**BN/97/25/PL**

*Land off Church Lane Barnham*

*Change of use of land from agricultural use to residential use, creating 4 No permanent private gypsy plots with associated parking, landscaping and facilities*

STREET SCENE BB [viewed from Church Lane] [1:200]

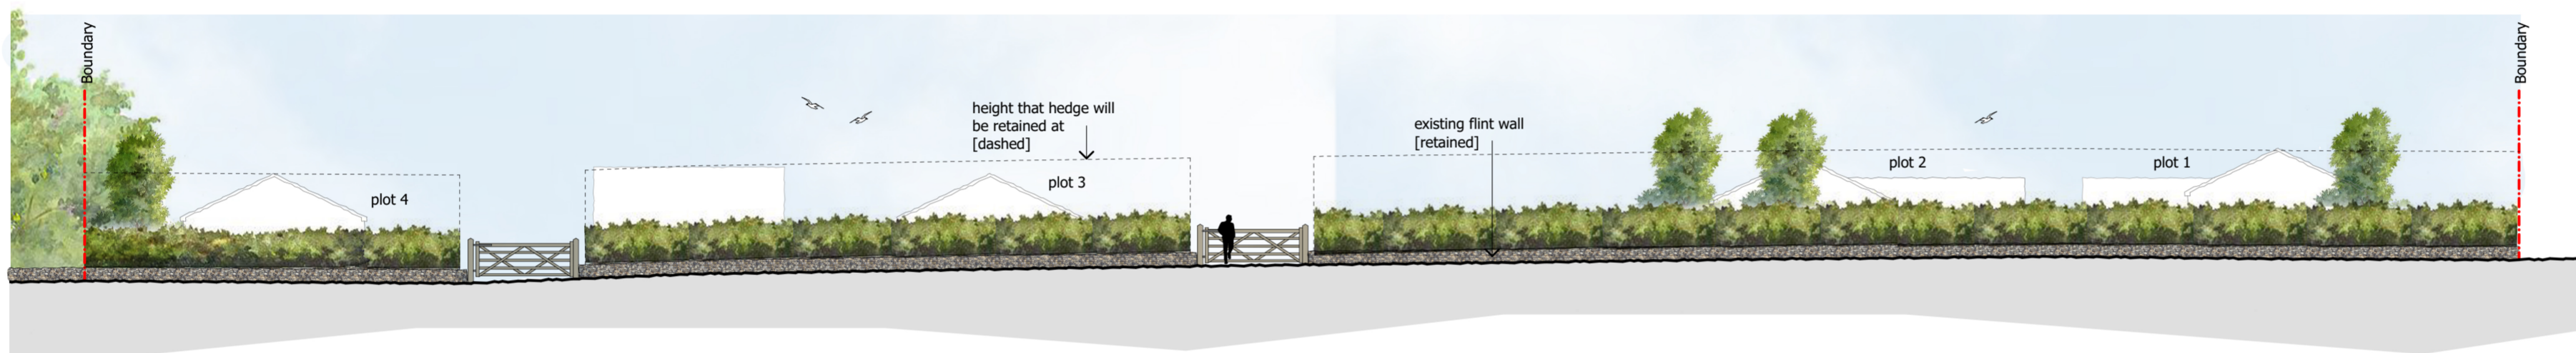
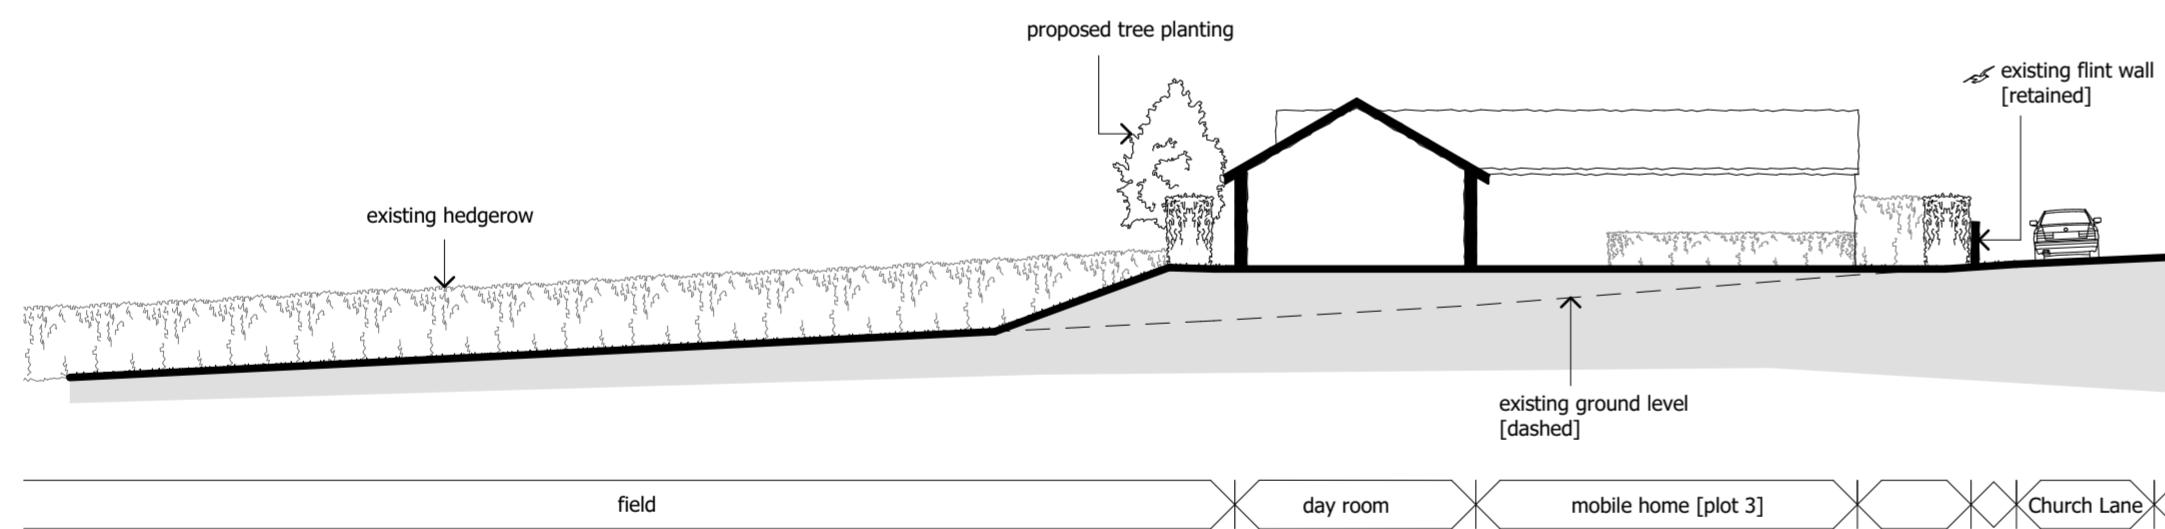
Additionally, the flood risk assessment indicates that land raising would be required in part of the site. This would further alter the character of the area and increase the prominence of the

development, exacerbating its impact on the surrounding context. This is evidence by the street view drawing.

Above: View 4 - from Church Lane

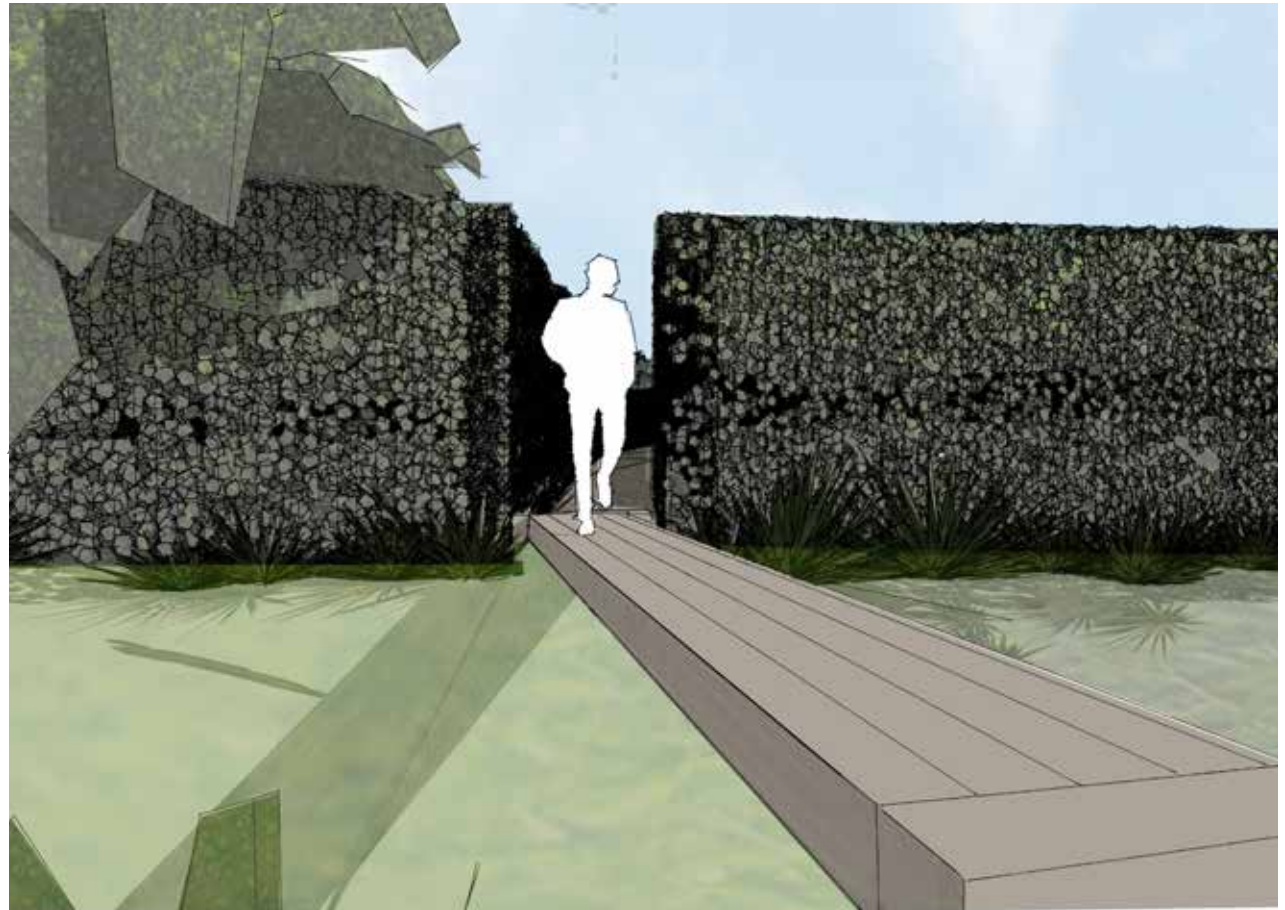
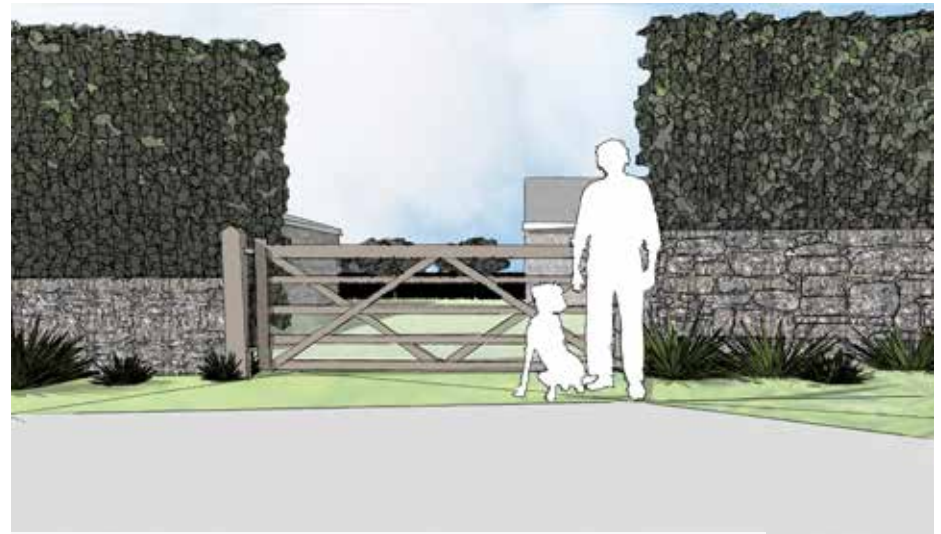
Further, I note that comments have been made that the hedging would screen the large housing estate in the fields further to the west. However, when I visited the site, I could look over the gate and still see the development being constructed. It is assumed that if permission were granted, this view would now be of the new proposed structures along with any of the new housing estate. This approach is confirmed by views 3 and 4 in the Design and Access Statement.
